KITTITAS COUNTY
DEPARTMENT OF PUBLIC WORKS

MEMORANDUM

TO: Noah Goodrich, Community Development Services
FROM: Christina Wollman, Planner II *CW*
DATE: December 20, 2006
SUBJECT: Sieber Short Plat

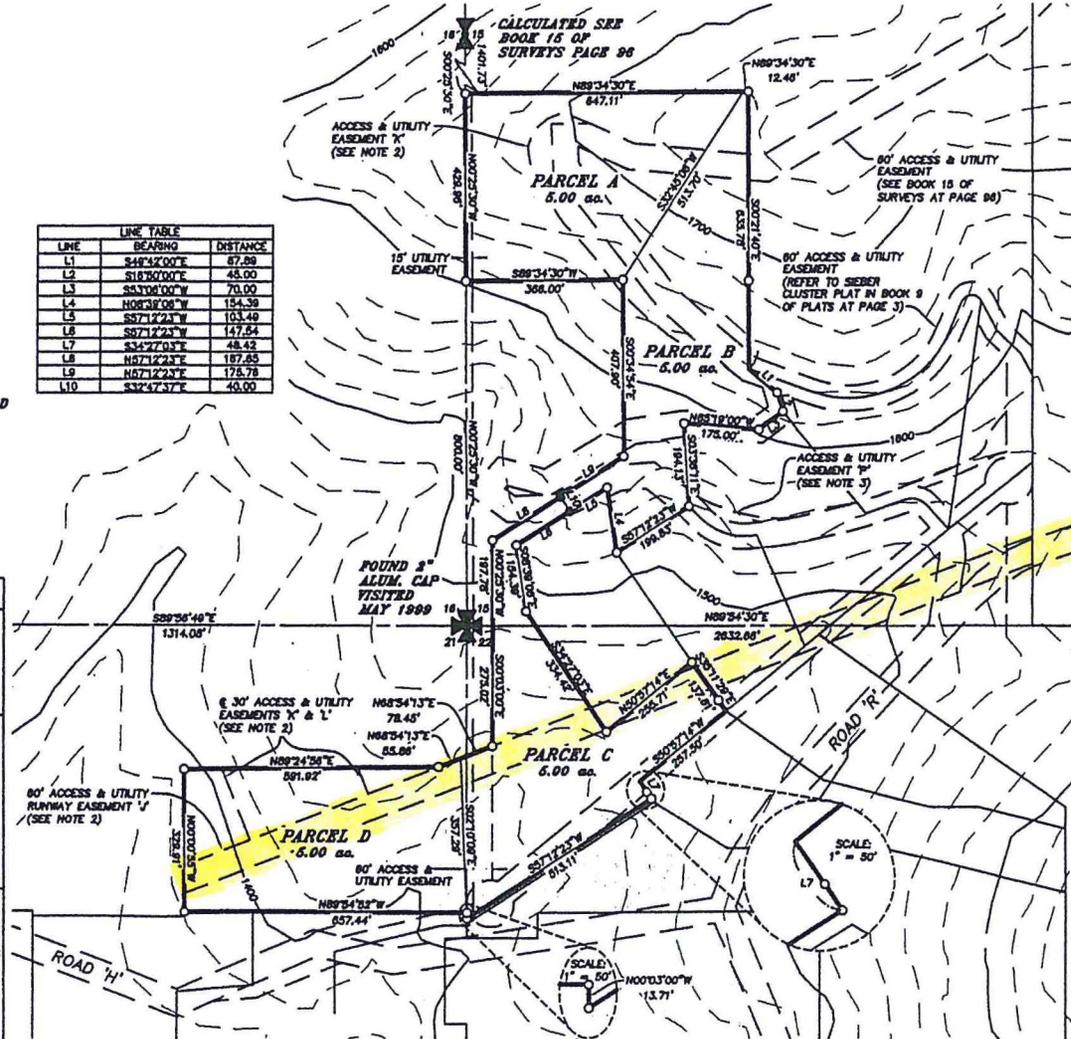
- a. The width of Easement 'P' shall be shown on the face of the plat.
 - b. Easement 'P' appears to serve three or more lots. Roads serving three or more lots are required to be built to the minimum standards of a high-density private road. These standards are shown above in condition #2.

- c. Easement 'P' is has a paved roadway width of approximately 15'. The roadway width for a private road serving three or more lots is 20' with 1' shoulders for a total width of 22'. Easement 'P' shall be widened to meet the minimum design standards required for this road type.
